Boston Alternative Energy Facility

Appendix E3 to Natural England's Deadline 5 Submission

Natural England's Comments on Public Rights of Way

25th January 2022

BOSTON ALTERNATIVE ENERGY FACILITY DEVELOPMENT CONSENT ORDER
 Regulation 5(2)(k) - Access and Rights of Way Plan
 BOSTON BOROUGH COUNCIL
 Sheet 1 of 1

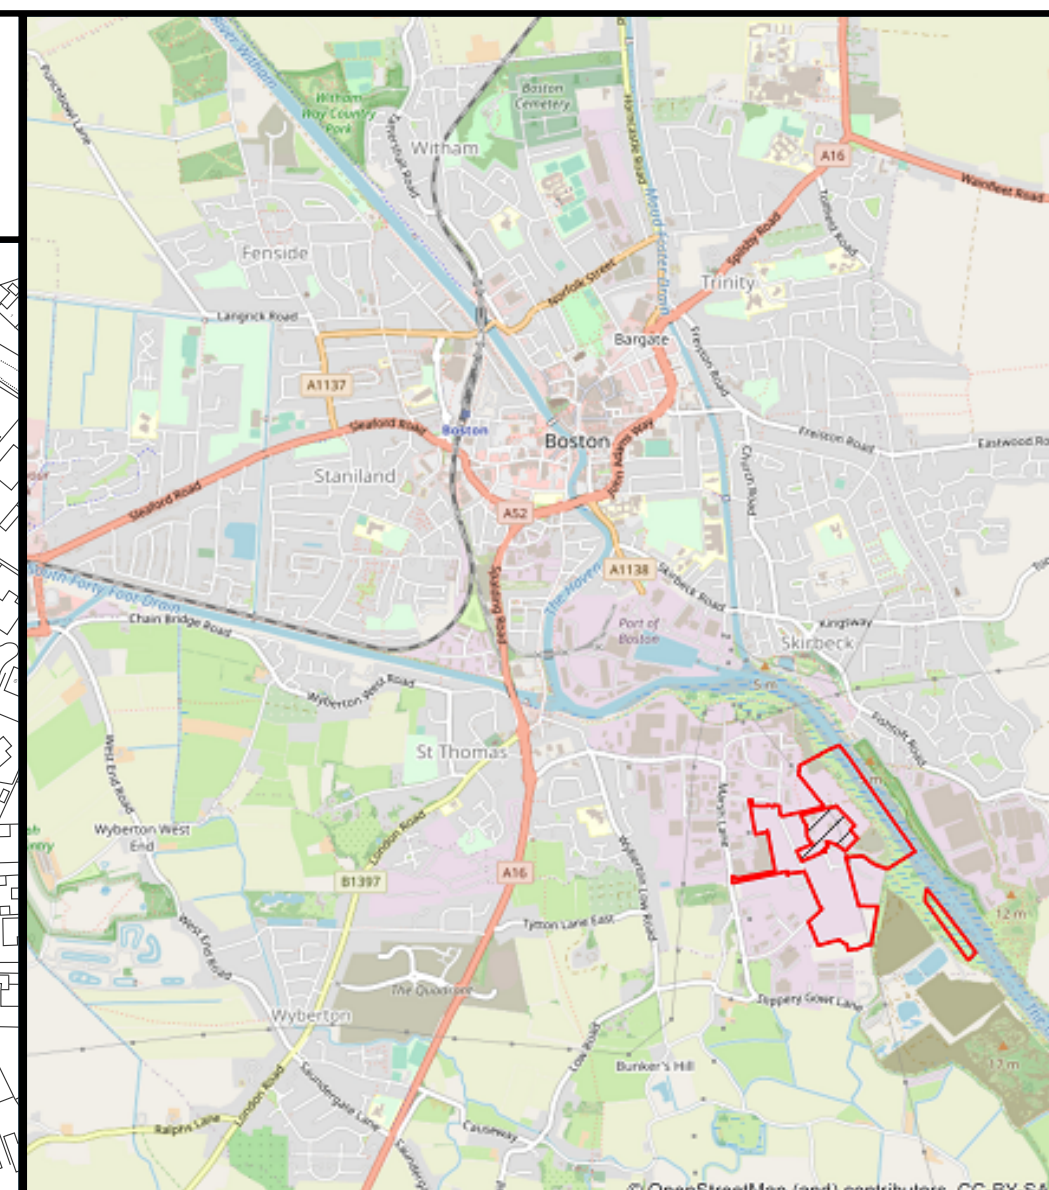
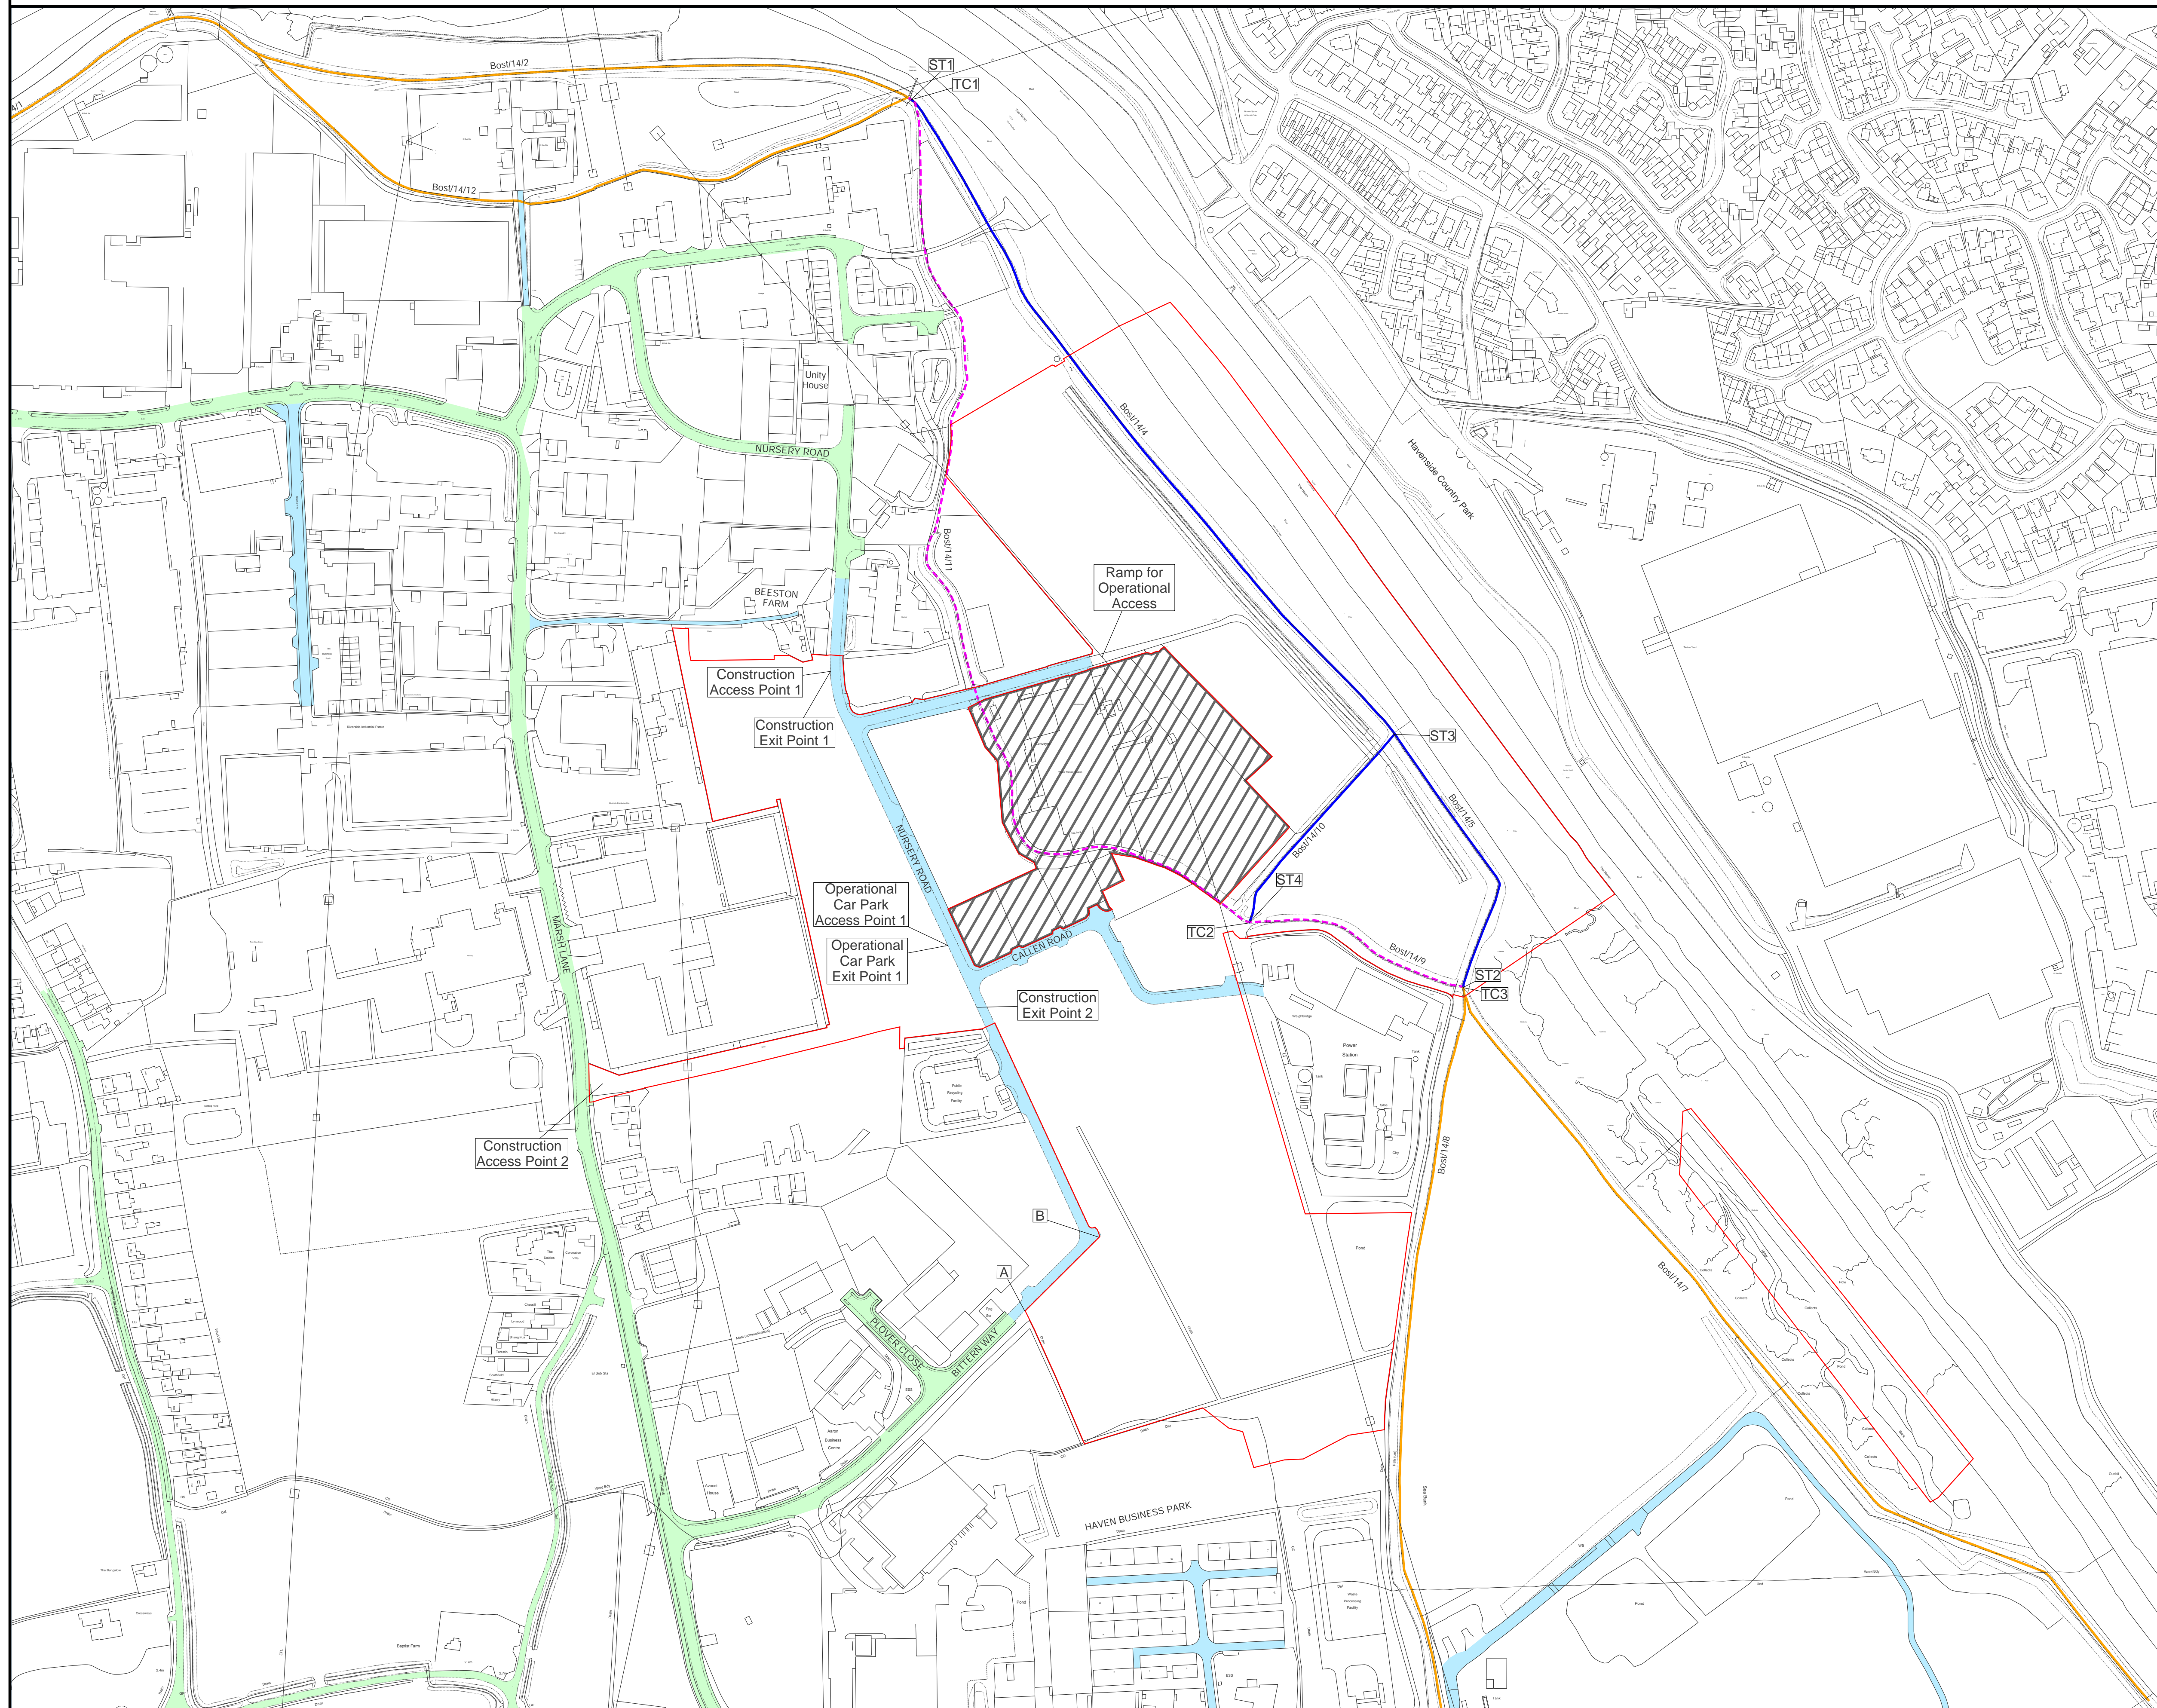
1. The emerging England Coast Path (ECP) route that follows the coastal margins of The Wash to Skegness is directly affected by the proposed BAEF. The proposed route of the ECP route would use public rights of way (BOST/14/4 and BOST/14/5) that front The Haven through the Principal Application Site. The proposal is to close these routes, and an alternative route has been provided via the existing Public Right of Way (BOST/14/11 and BOST/14/9), which follows the route of Roman Bank (also known as 'Sea Bank')

3. Following discussion with the Applicant and Lincolnshire County Council, Natural England suggested an alternative to the proposed diversion route [REP2-047]. This alternative would continue with approximately 200m of the northern section of BOST/14/4 and introduce a short new section of footpath (110m) which would join BOST/14/11. Natural England's reasoning for this suggested alternative was that it would maintain greater access to the sea which is one of the main purposes of the ECP as set out within the Marine and Coastal Access Act 2009.

8. Natural England therefore needs to ensure that access to the 'coast' must be restricted in the smallest possible way which is our reasoning for suggesting an alternative route as discussed above.

9. Whilst we understand the reasons put forward by the Applicant for not favouring this suggested alternative, Natural England suggests that none of the reasons are necessarily a consideration for the ECP. Landowner permission is not needed to establish the ECP route. Removal of natural vegetation to facilitate the route is acceptable, and security concerns are only a concern if the route was within the curtilage of a building.

10. Natural England therefore advises that whilst the section of footpath involved is small (200m), it provides direct access to coast and would therefore uphold the aims of the England Coastal Path. We would therefore maintain our suggested alternative route which directly follows the coast.
